Ref: APP/2023/1823

Full Planning Permission for Erection of Garage and Ancillary Accommodation at Twelve Oaks, Premnay, Insch, AB52 6PS

Drawing Number
 2326-P-005

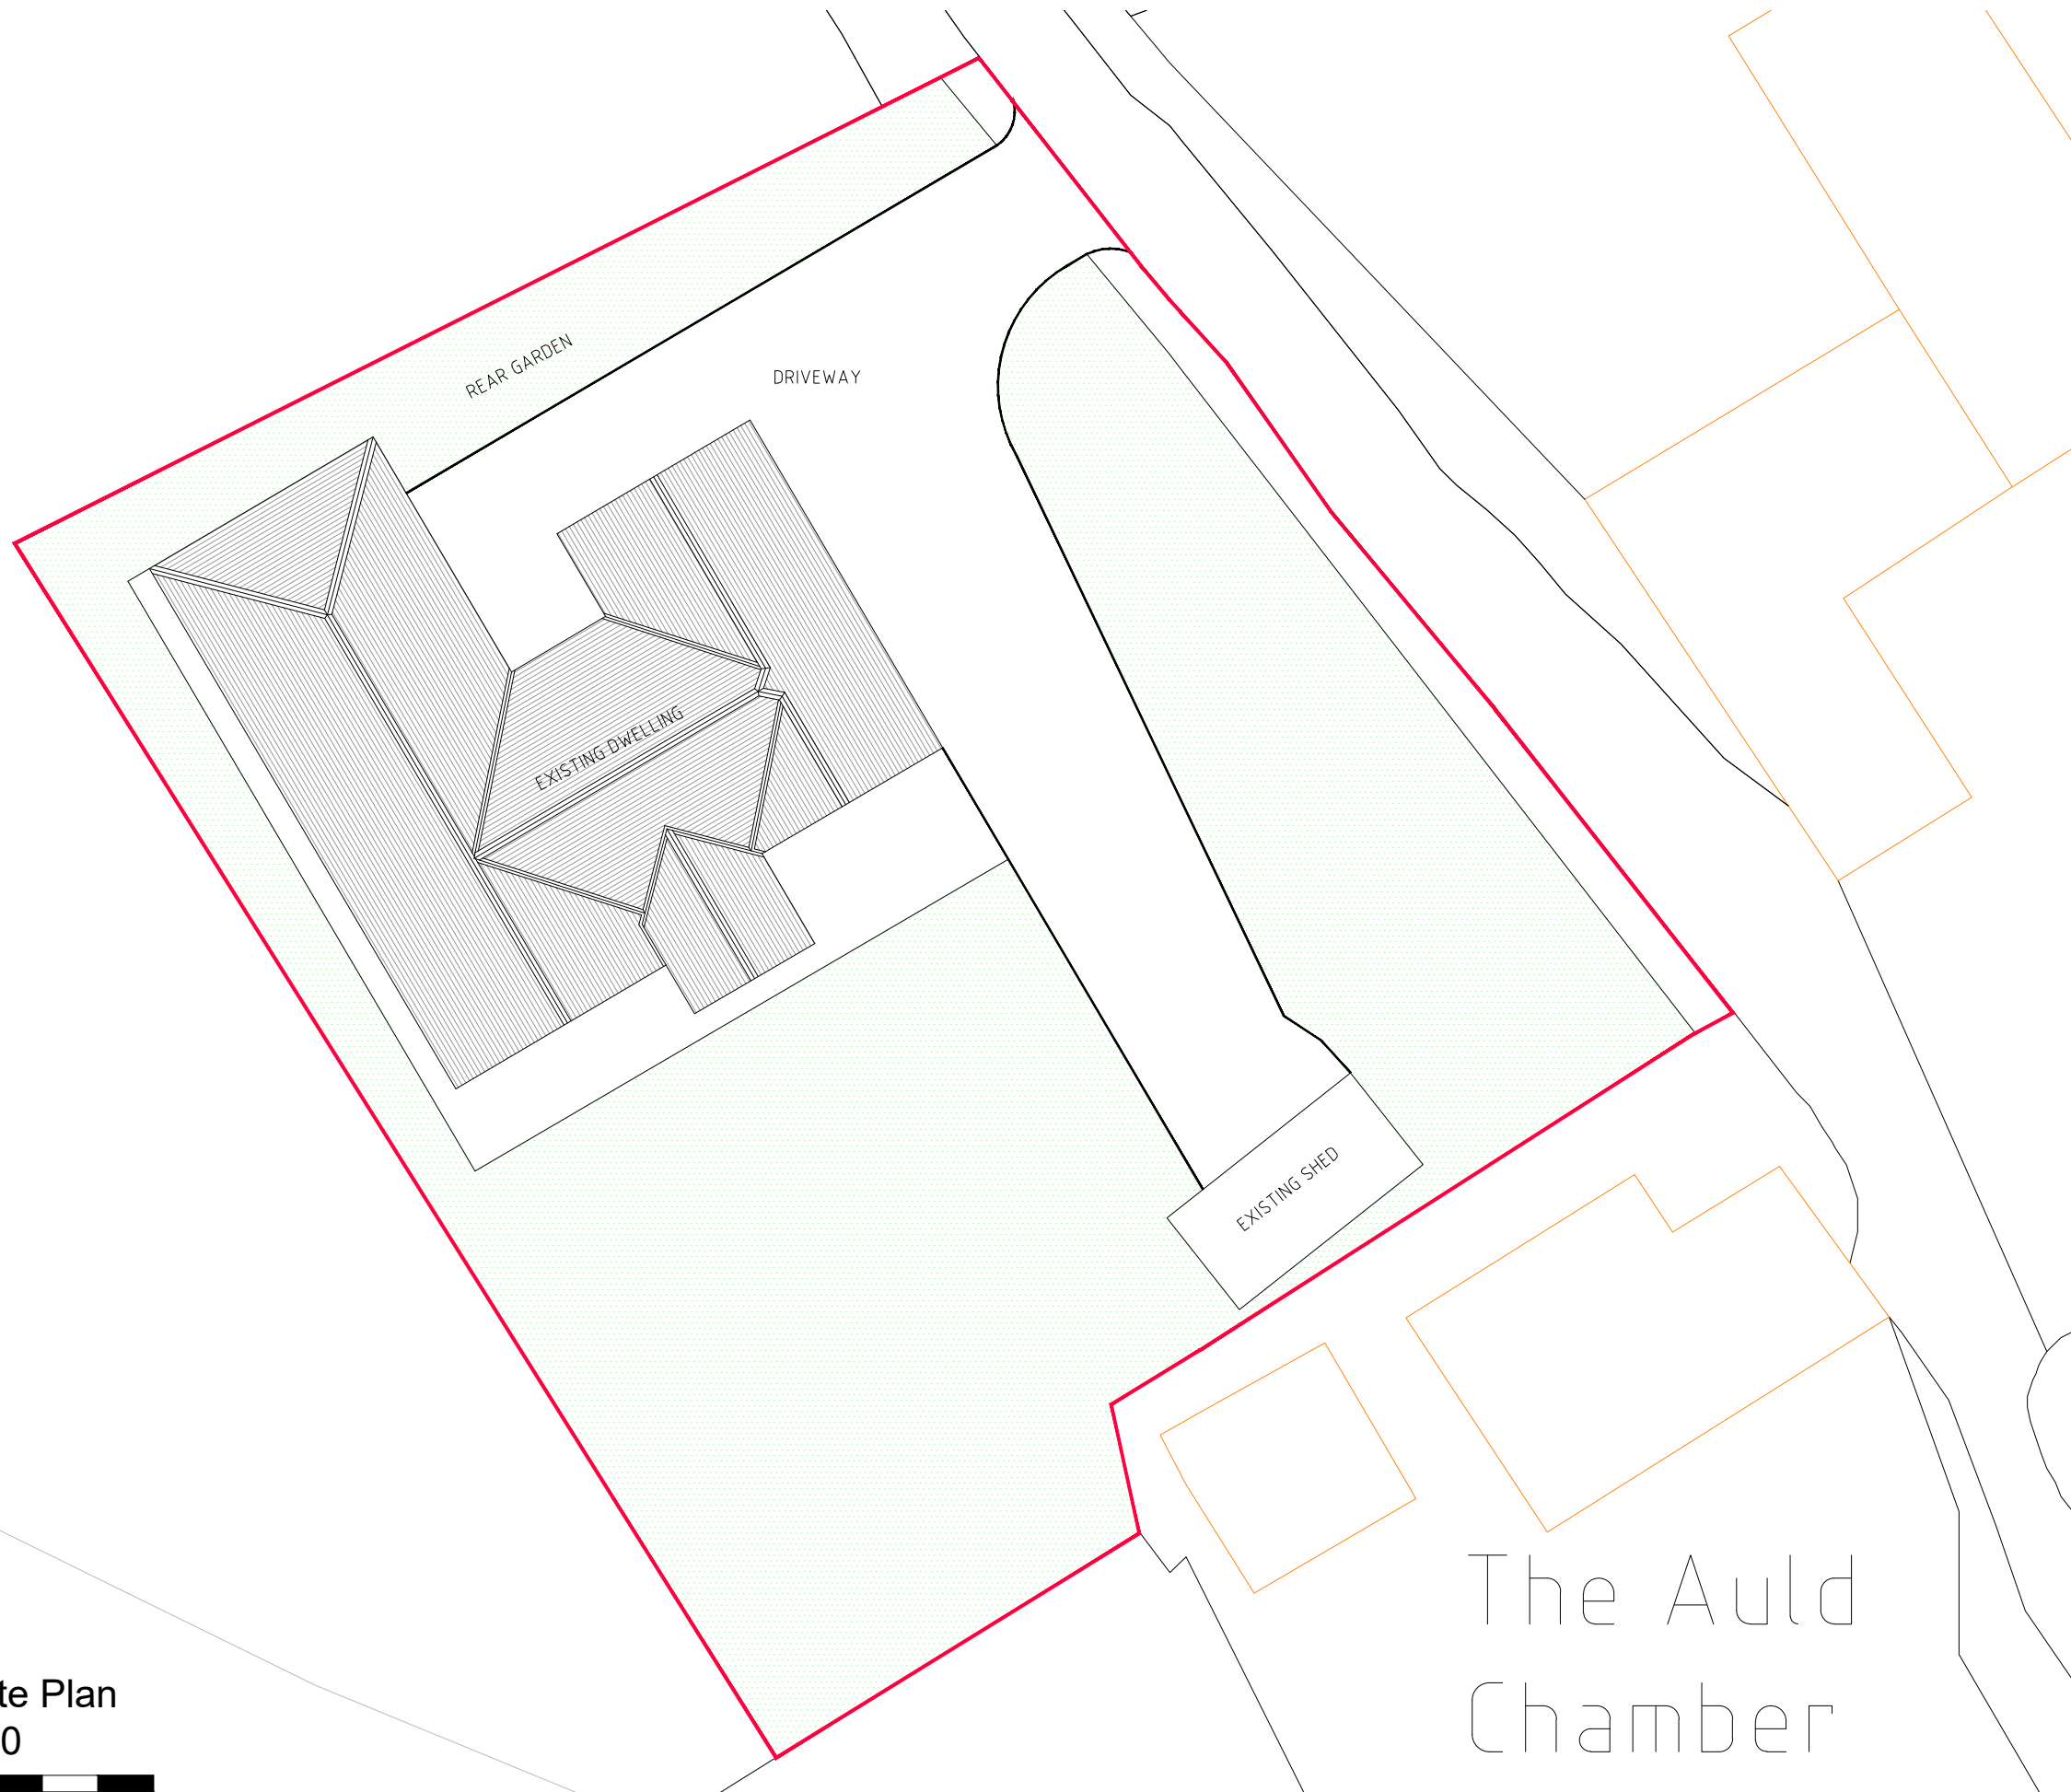
2. Submit an existing site plan.
See dwg. 2326-P-005.
3. As the site is in the countryside please submit an Ordnance survey plan at a scale of 1:10,000 (or appropriate) showing the site in relation to the nearest settlement or popular landmark, this is required for both members of the public viewing the application and members of Council staff who undertake site visits.
See dwg. 2326-P-004.

Drawing Number	Date	Revision	Drawing By	Scale
2326-P-002A	27.09.23	A	JW	As noted (A1)
Drawing Status PLANNING

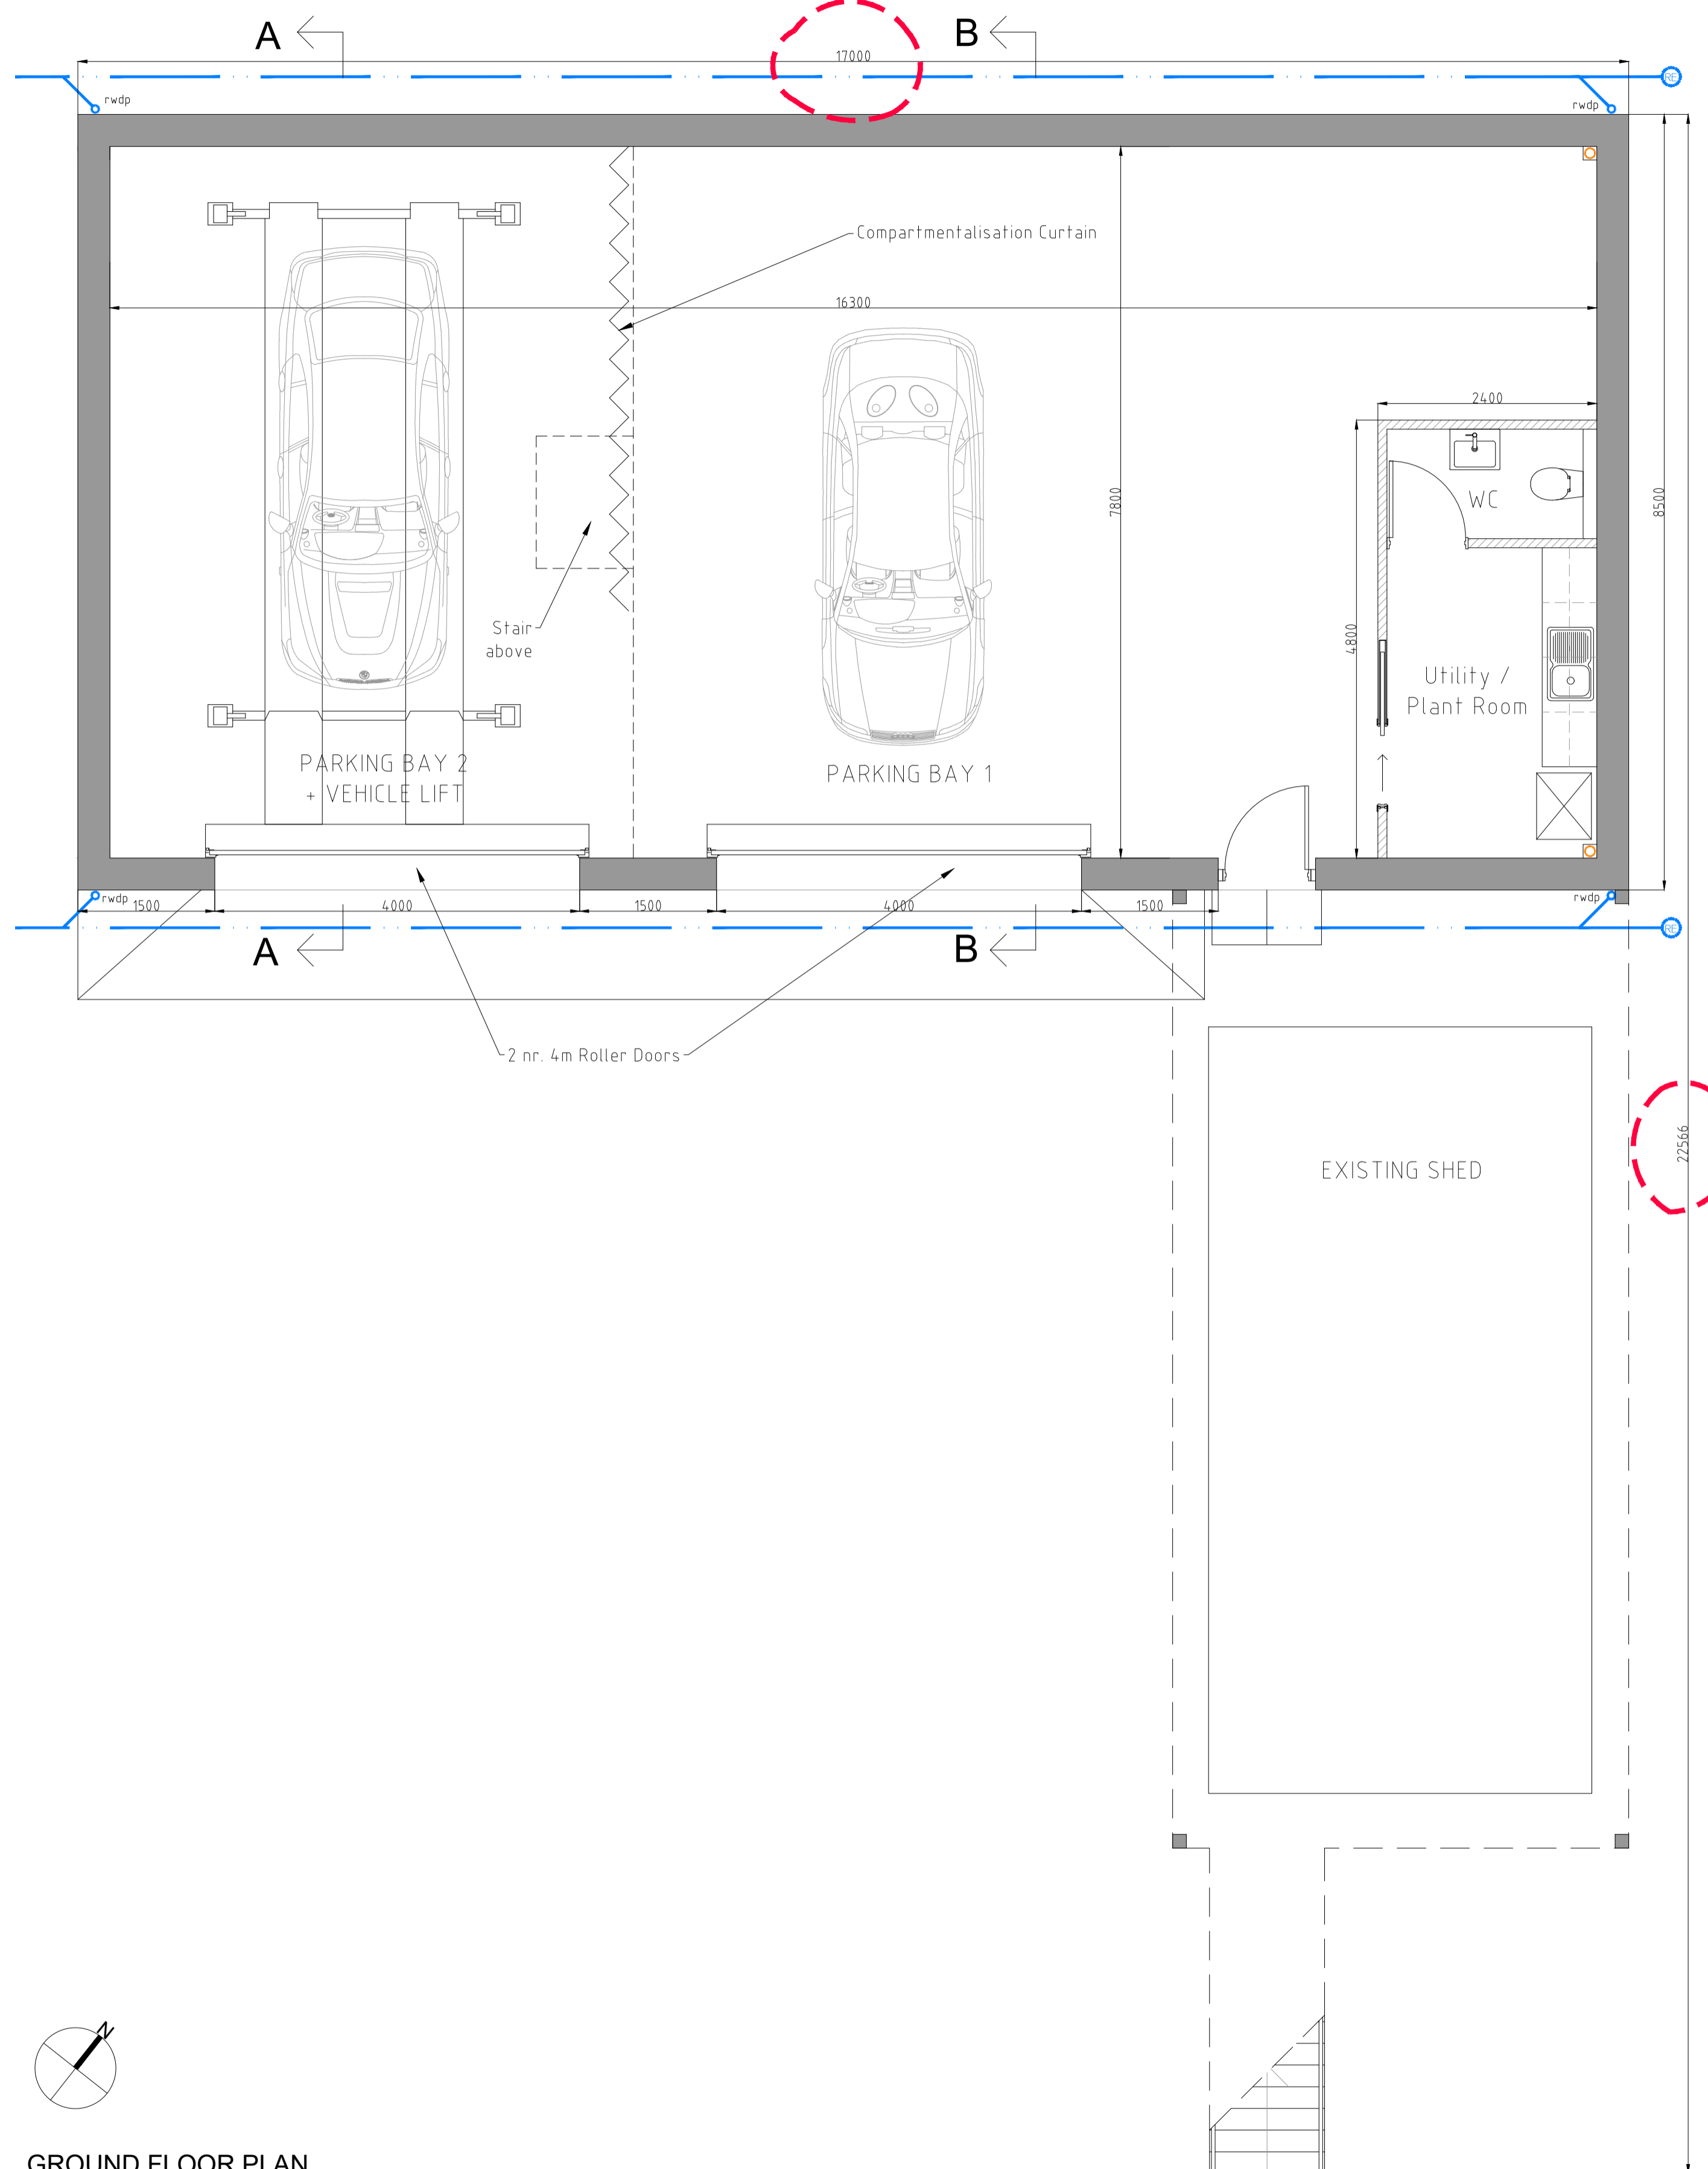
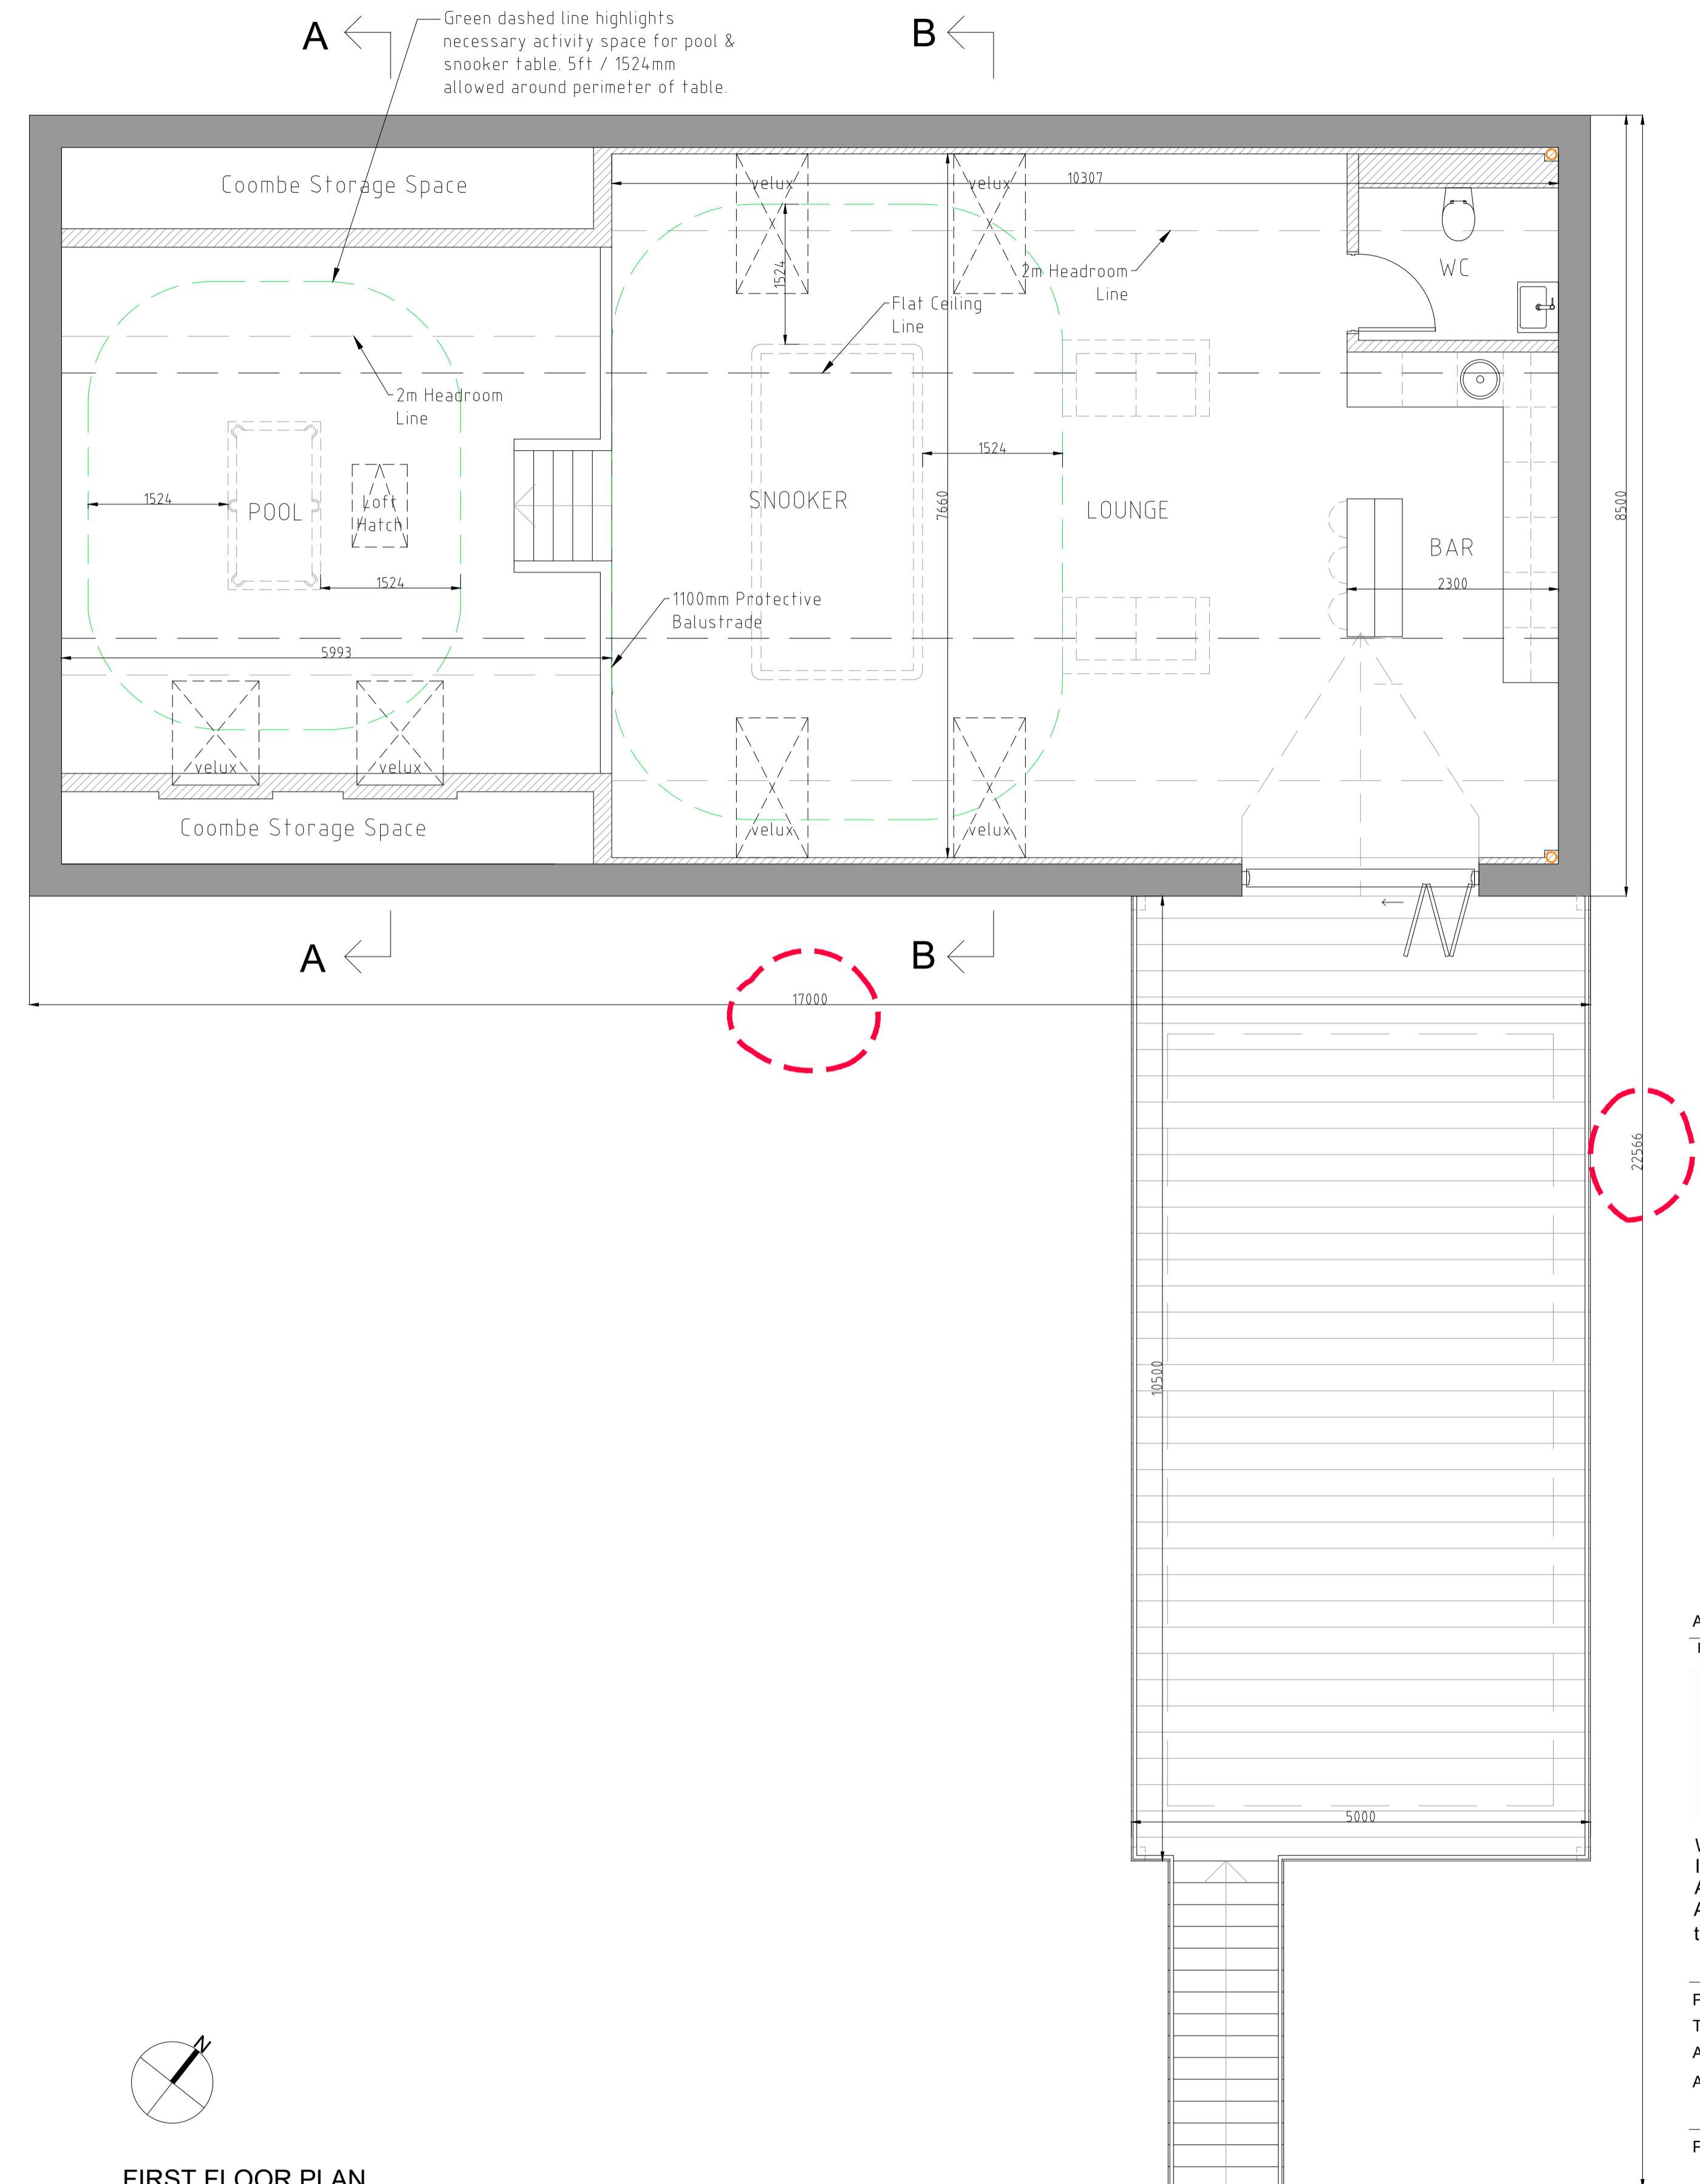
4. Add scale bars to all drawings.
See revised dwgs. 2326-P-002A & 2326-P-003A.
5. On the floor plan add written dimensions of the overall length and width.
See revised dwg. 2326-P-002A.
